from
**Southern
Water**

Your ref
BN/66/19/PL

Proposal: Erection of 2 No dwellings.

Site: BN/66/19/PL: - Land off Canal Mews, Barnham, PO22 0DP.

Studio Lack Architecture Studio Lack Ltd : 17 Beech Avenue : Chichester 01243 782 686 : nicholas.lack@live.com : PO19 3DR	Land off Canal Mews Barnham	Site Layout 11/01/20 1/200 @ A3	Dwg 1705-12H
--	--	---	---------------------

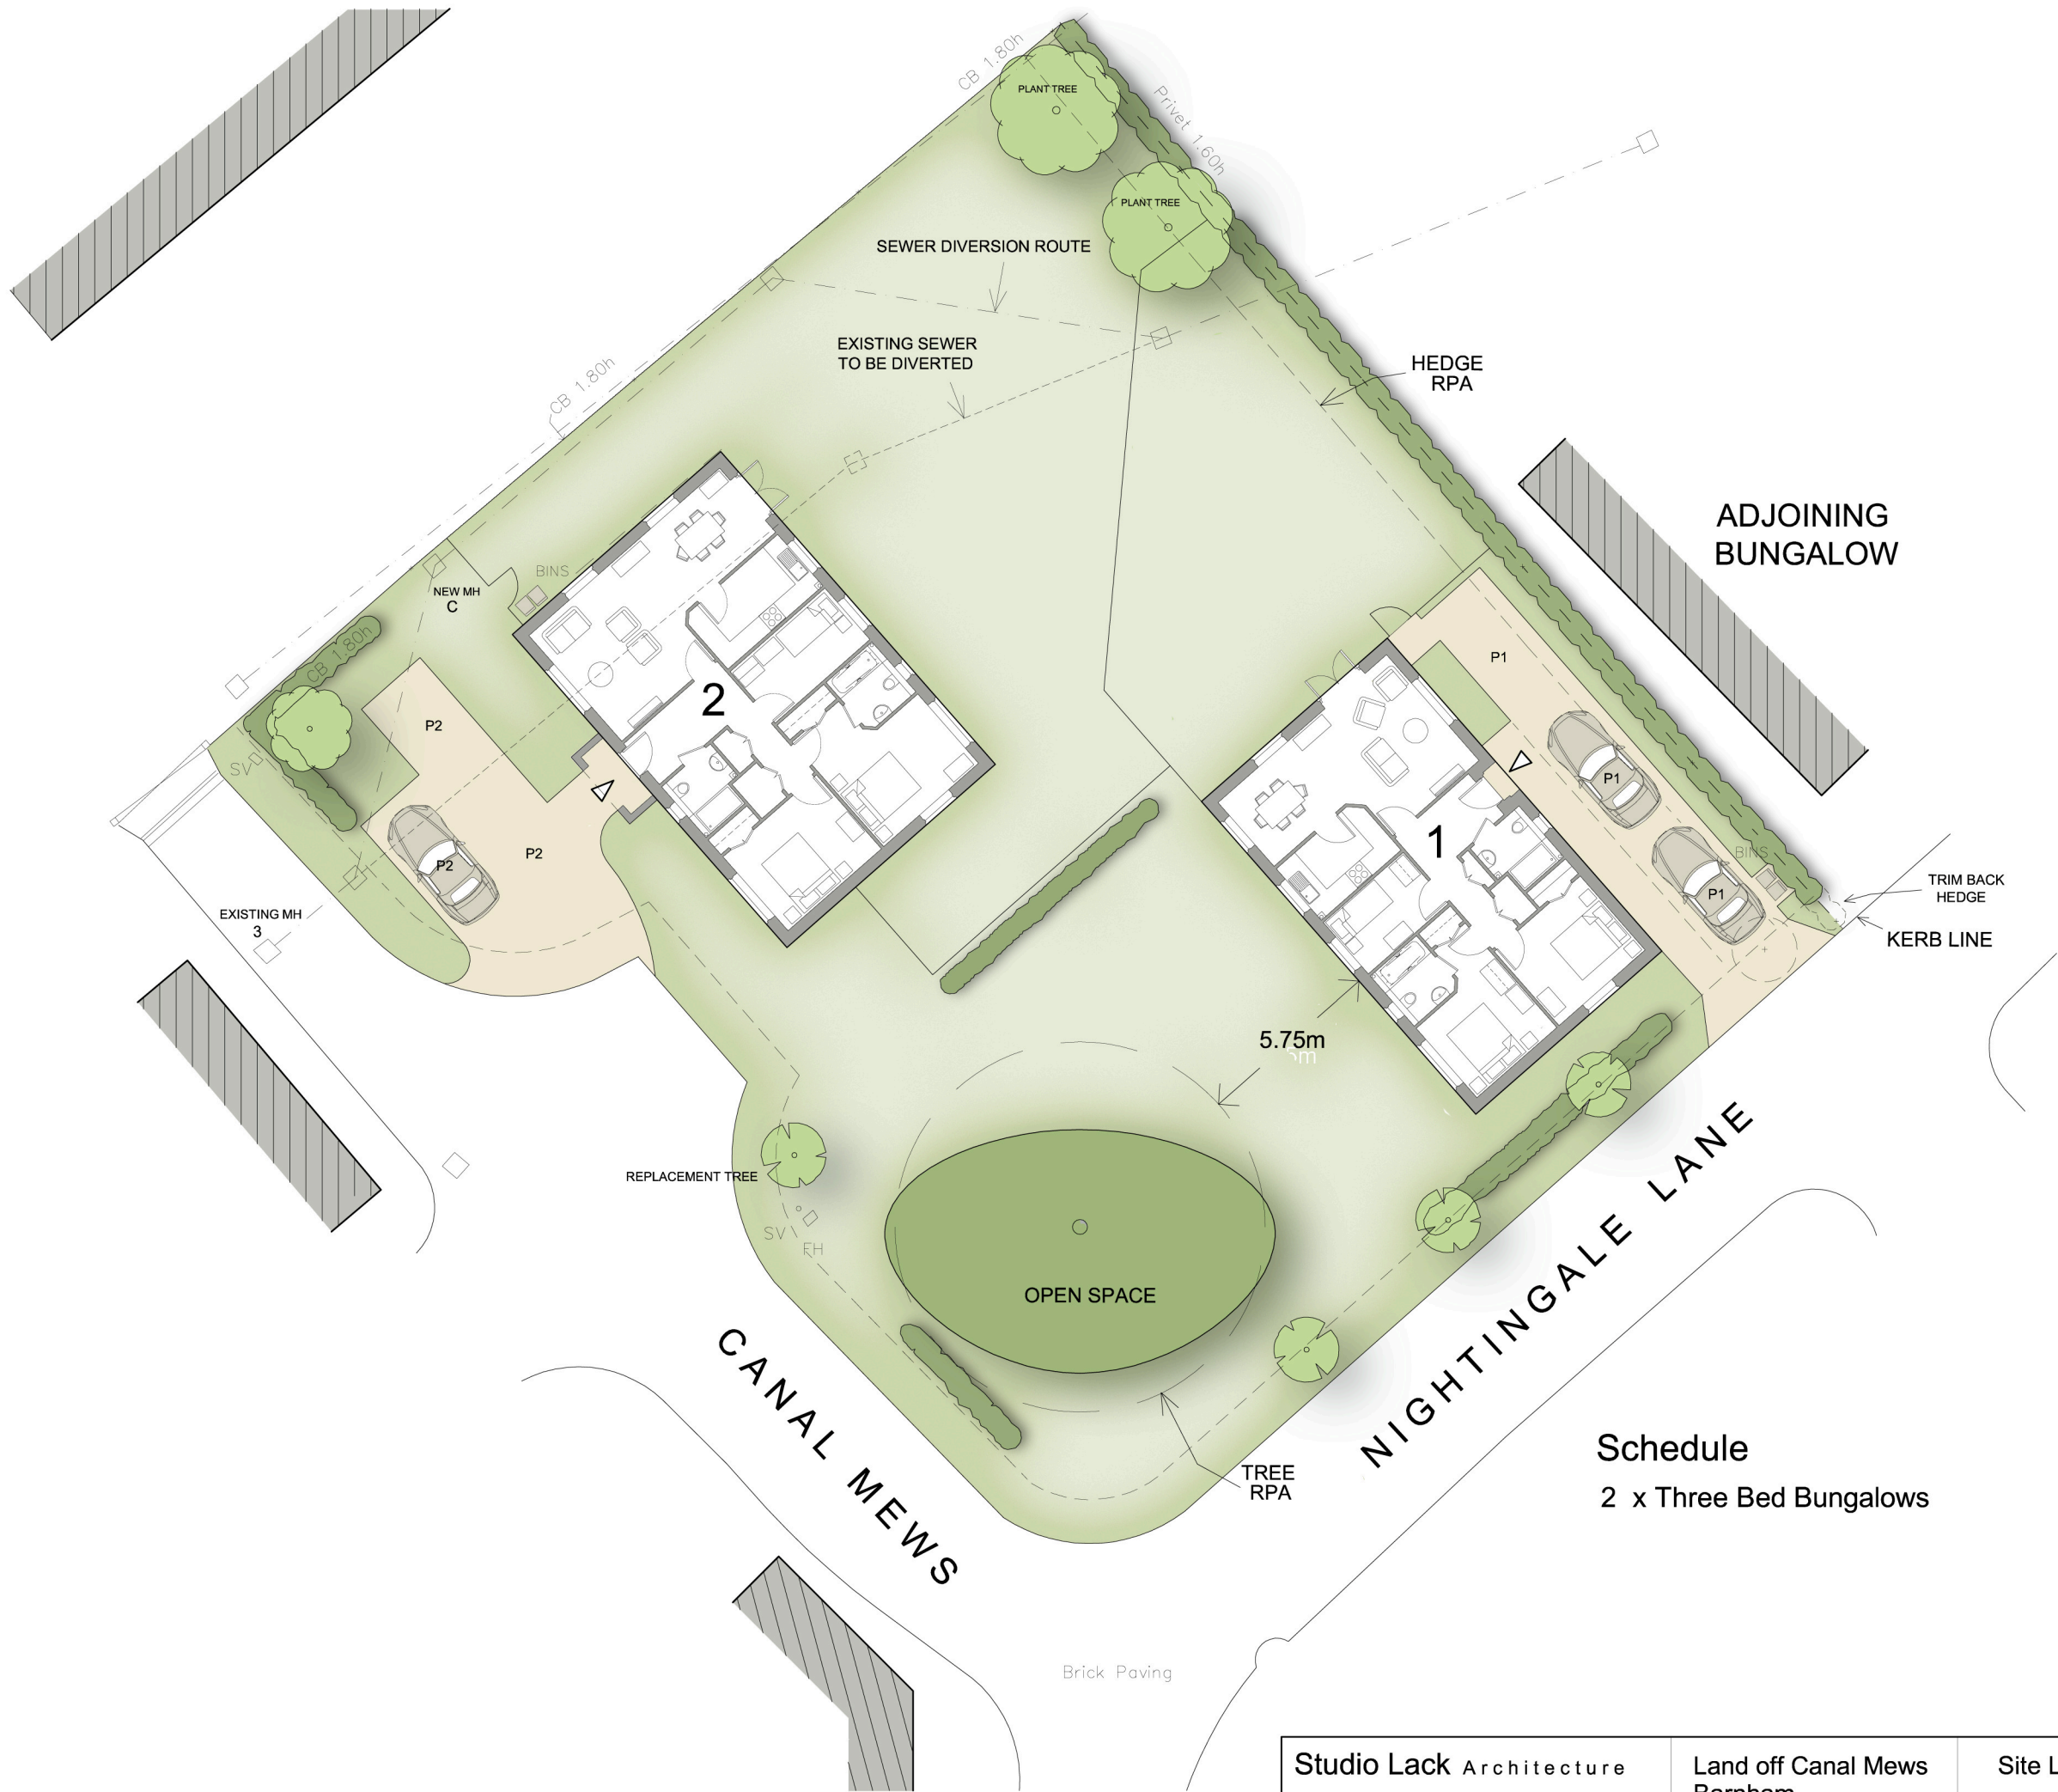
It appears that applicant is proposing to divert public sewer (not shown on our records). Southern Water requests a formal application for sewer diversion under S185 of Water Industry Act 1991 in order to divert any public sewer.

It is possible that a sewer now deemed to be public could be crossing the development site. Therefore, should any sewer be found during construction works, an investigation of the sewer will be required to ascertain its ownership before any further works commence on site.
